2024/0760

Lynton, Broad Carr Road, Hoyland, Barnsley, S74 9BT

**Erection of single storey side extension and rendering of all elevations of dwelling at ground floor level. (Amendment to previous application 2024/0214).**

PROPOSED PLANS & ELEVATIONS

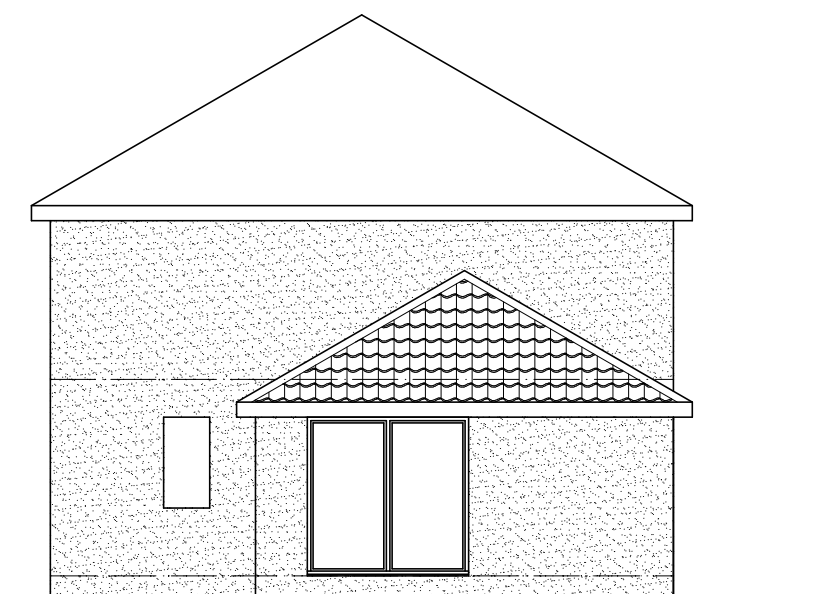
During the application process, the amount of rendering proposed to all elevations of the existing dwelling was reduced to be limited to ground level in the interests of the visual amenities of the locality.

The original proposal included the rendering of all elevations however this was not considered to be appropriate given the semi-detached nature of the dwelling. The rendering of all elevations would make the dwelling appear out of place when viewed in relation to the brick attached property. Subsequently, the proposal was amended and the amount of rendering proposed was reduced and limited to ground level with brickwork being maintained at first-floor level. Moreover, the application property is set back and down from the highway and is bounded by various mixed vegetation which offer some screening, soften the appearance of the proposed development in the street scene and reduce its prominence. The proposed roofing materials would also closely match those used on the existing roof. The proposal is therefore not considered to significantly alter or detract from the character of the street scene.
